date: July 31, 2007
project: WAYNFLETE ARTS CENTER, PHASE TWO, 2003-0040
re: Planning Board Public Hearing material
to: Shukria Wiar, Planner City of Portland
Anne Hagstrom Waynflete
from: Austin Smith Scott Simons Architects (SSA)

MEMORANDUM Site Plan Memorandum

MEMORANDUM Site Plan Punchlist Memorandum

date: July 3, 2007
project: WAYNFLETE ARTS CENTER, PHASE TWO, 2003-0040
re: Major Development, Site Plan Punchlist questions of May 31, 2007
to: Shukria Wiar
 Planning Department City of Portland
from: Austin Smith Scott Simons Architects (SSA)
cc: Scott Simons SSA
 Charles Young SSA
 Anne Hagstrom Waynflete
 David Cimino Stroudwater

WAYNFLETE ARTS CENTER
360 SPRING STREET, PORTLAND, MAINE
Mechanical Screening at RTU

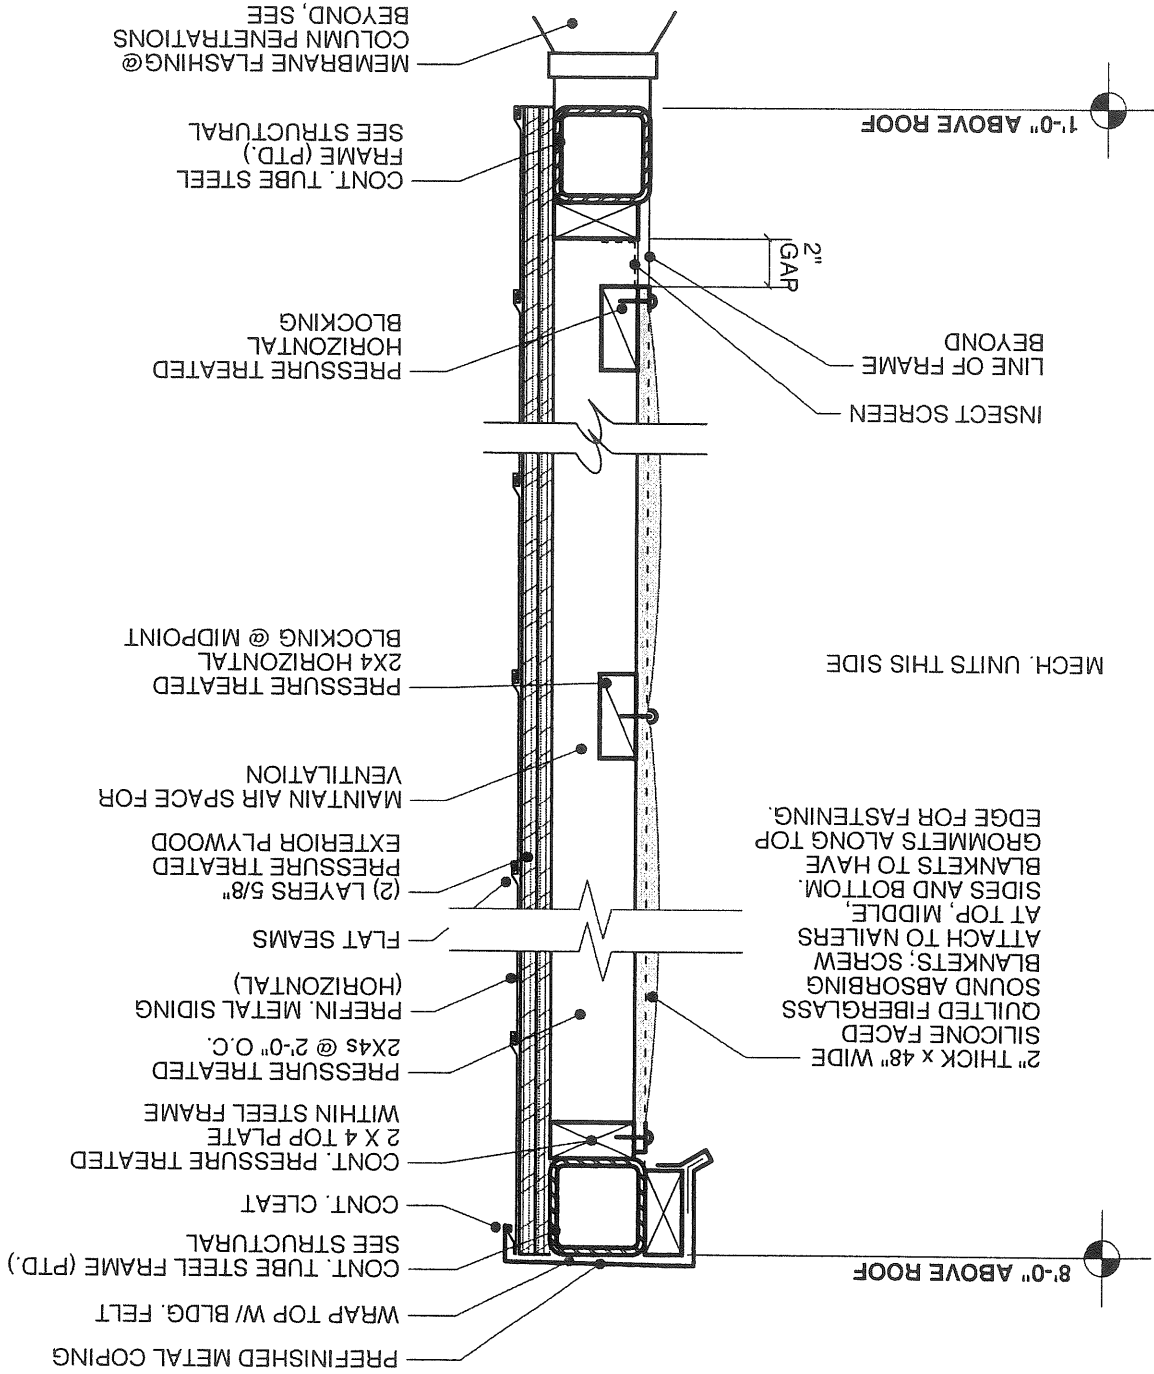
16. *The project proposes a new roof top mechanical unit, submit evidence of the measurement to be taken to lower the noise level.*

The roof top mechanical unit was previously shown centered on roof of the future gymnasium; running east/west. This will be repositioned to run north/south and moved to the far east side of the roof to lessen its visual impact. Unit will be ducted from the bottom lowering the overall height of the unit by 4 feet. The revised position is reflected on the enclosed revised drawing A-1.3, dated July 2, 2007.

In addition to the repositioning of the unit, acoustic mechanical screening will be incorporated.

Detail SK-3 shows the construction and configuration of the visual and acoustic barrier.

Figure C
Danforth Street at Fletcher
View from north sidewalk

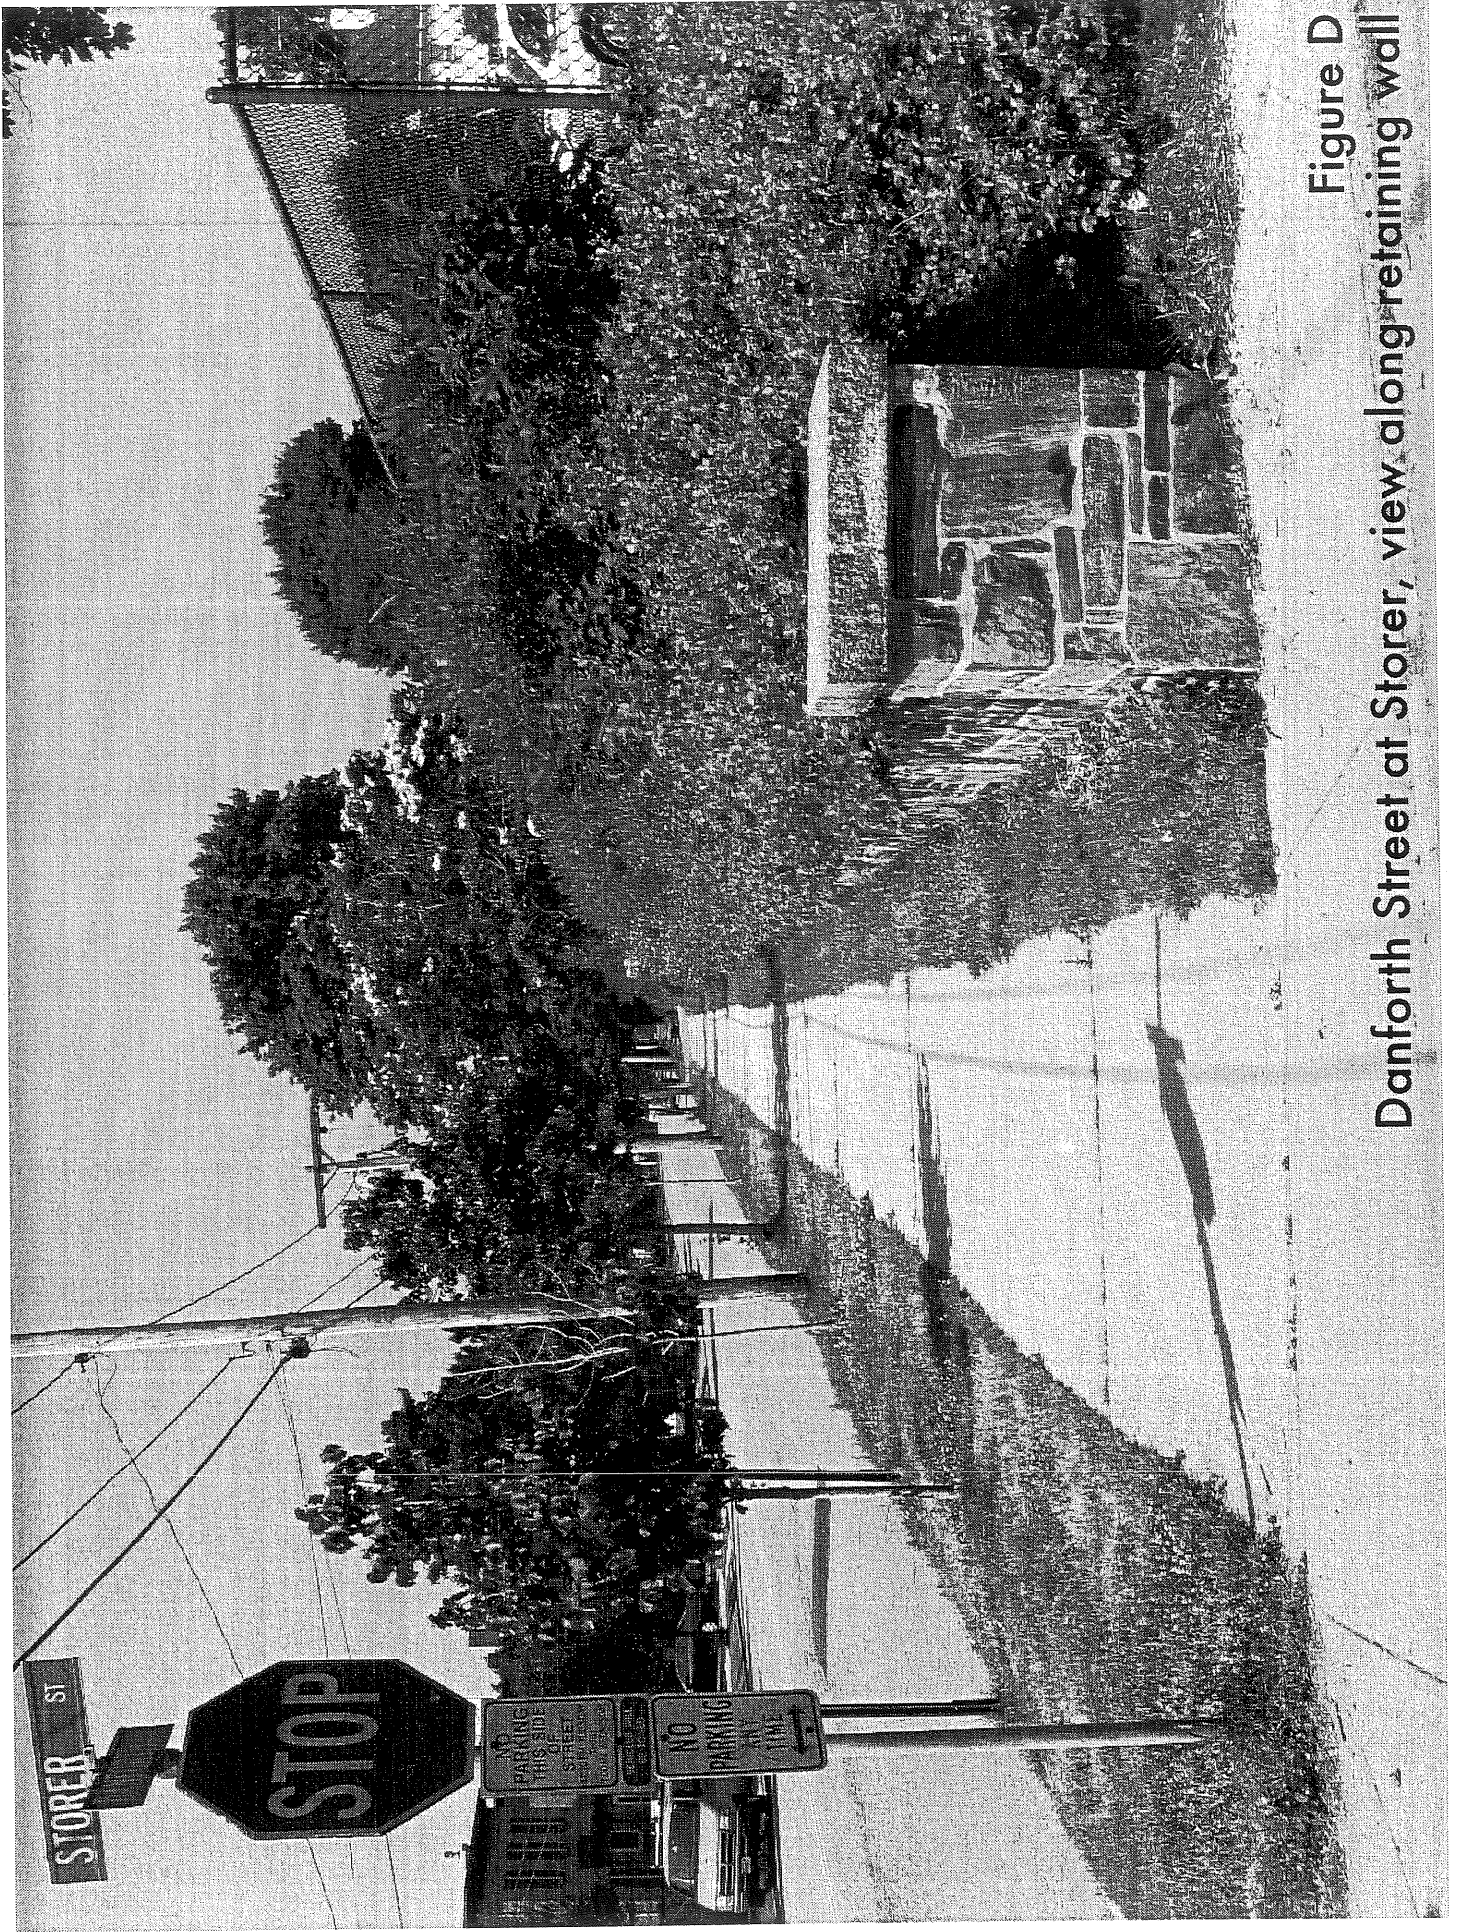
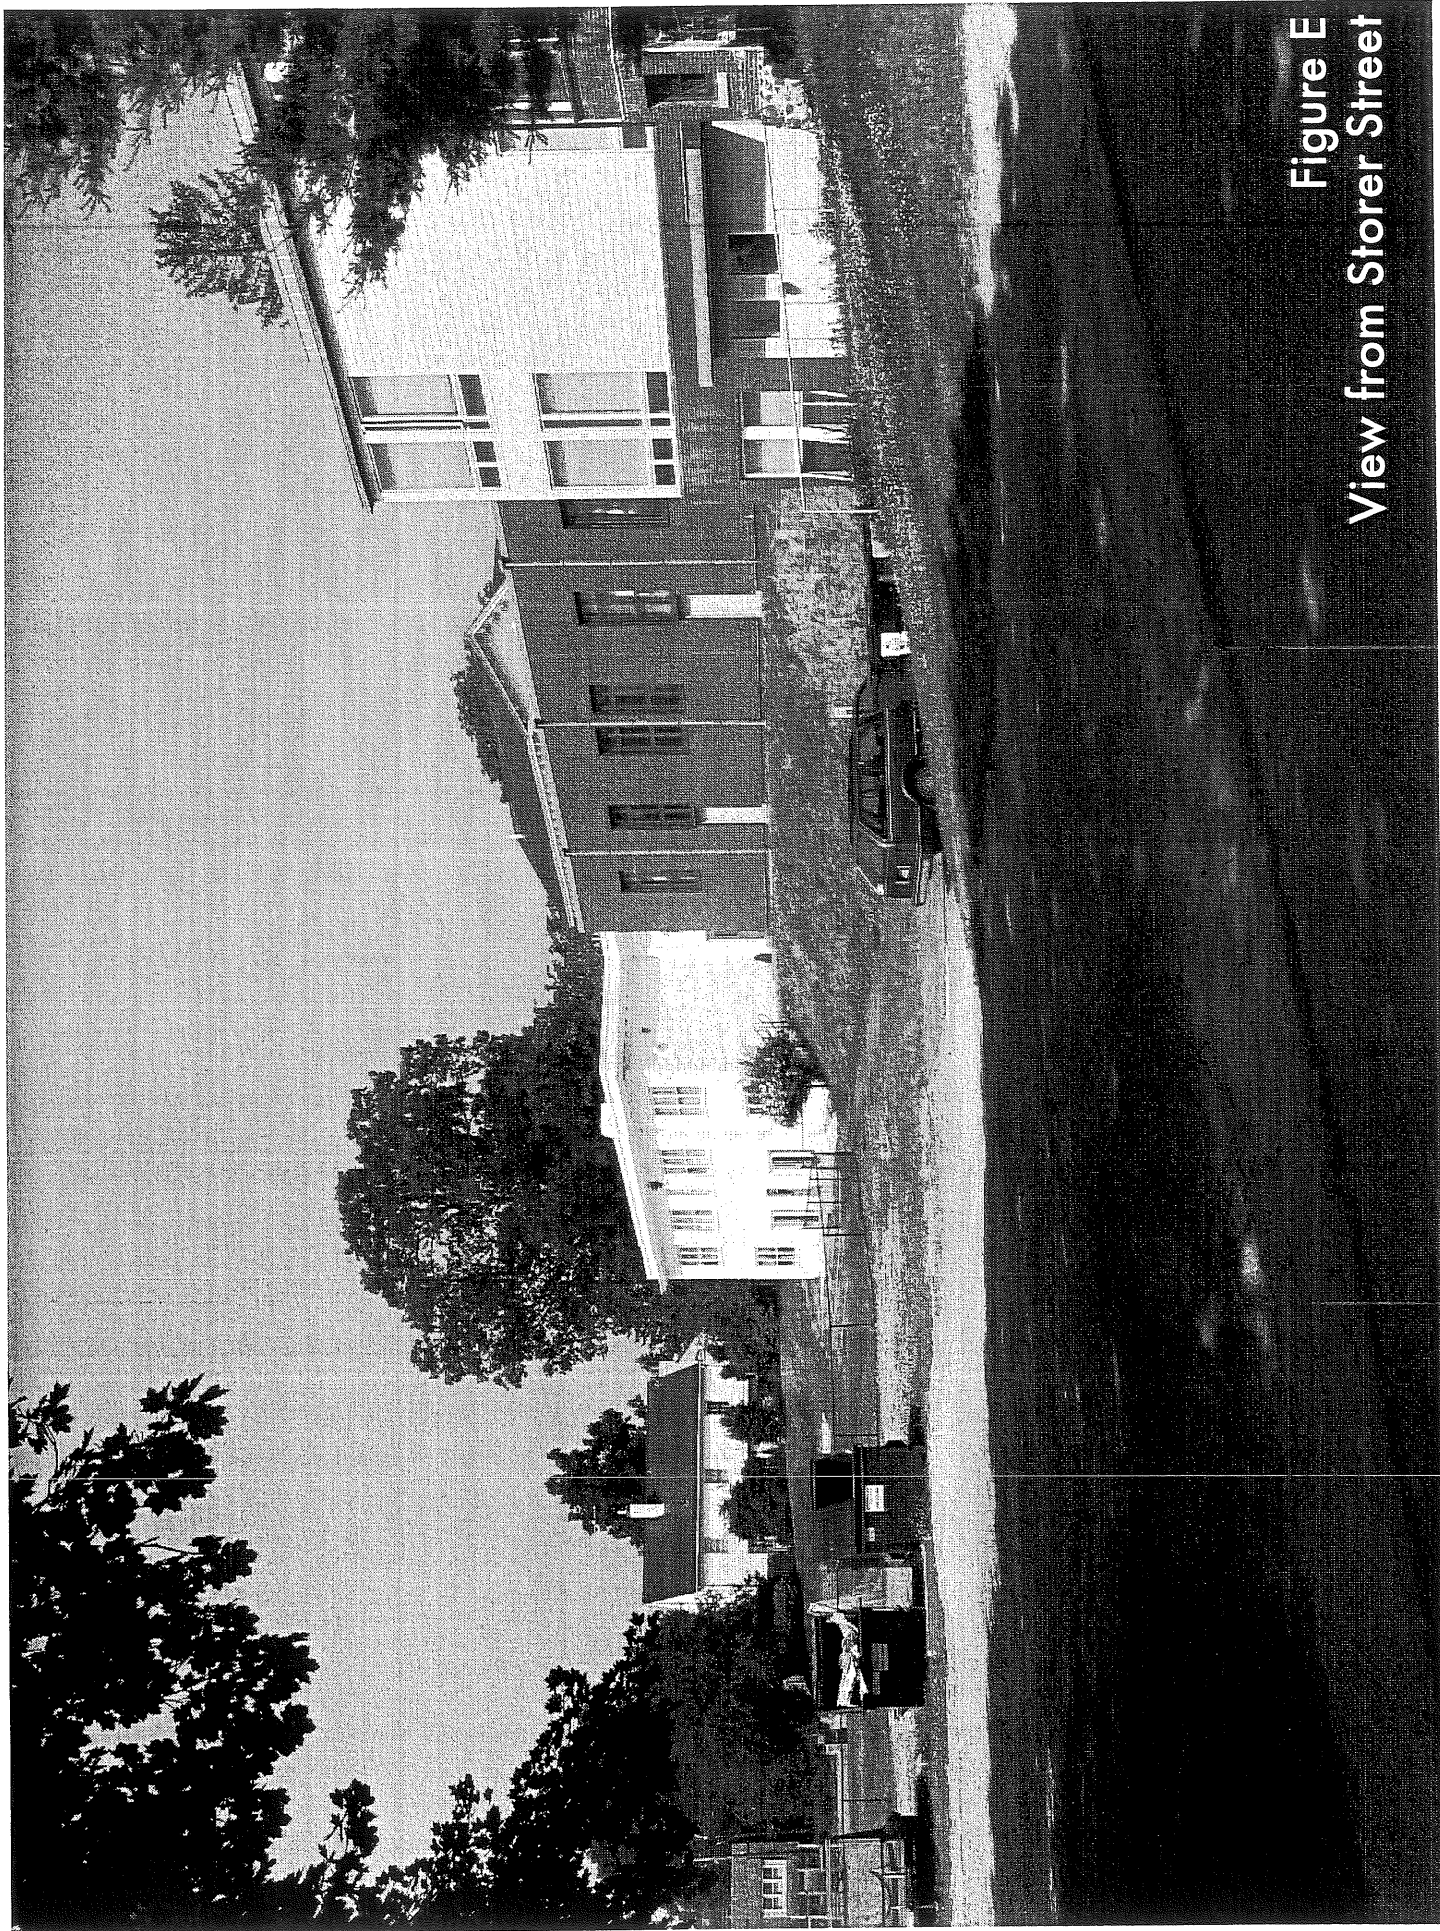
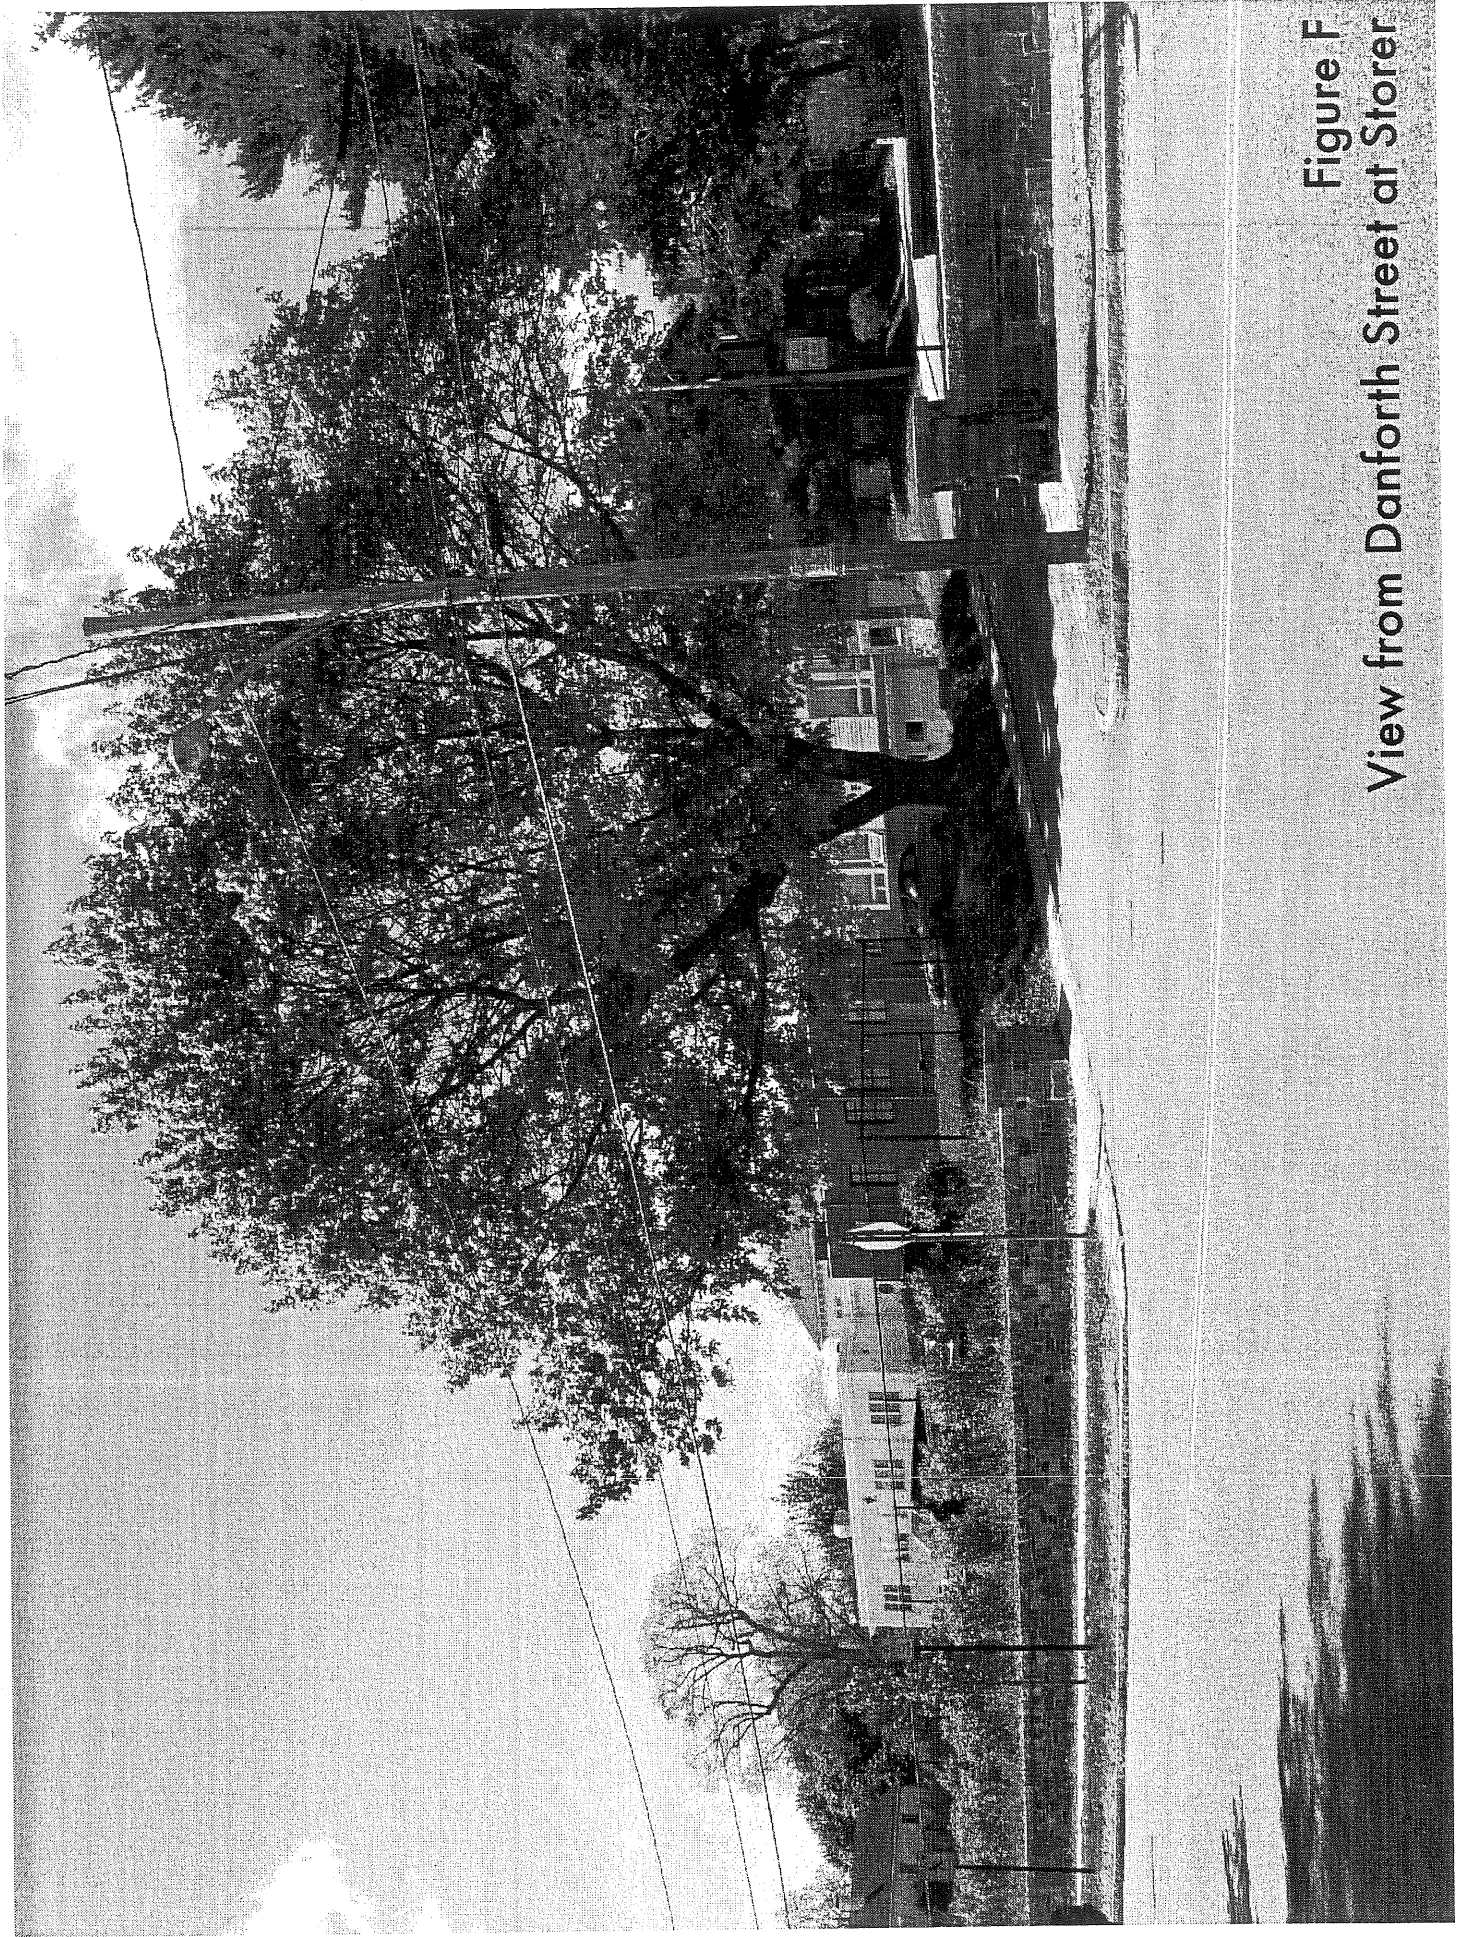
- d. *New Handicapped ramps should be constructed at the corner of Storer and Danforth Streets. The associated details will need to be included.*

- e. *The conditions of the existing sidewalk should be indicated.*

Concerning both items d. and e. please note the condition of Storer Street edge, curb and sidewalk in the enclosed photographs. In 2003 a new paving overlay was installed on Storer between Spring and Danforth Street. This raised the top of paving to within 1" to 1 ½" of top of curb. Without addressing the pavement elevation, it is difficult to reset curb heights for long term ADA compliance.

Existing sidewalk of the west side of Storer Street is cast in place concrete with granite curbing. See enclosed photographs of existing site conditions including Storer Street curbing / sidewalk , existing Norway Maple tree and Danforth Street sidewalk, stone retaining wall, plantings, and fencing.
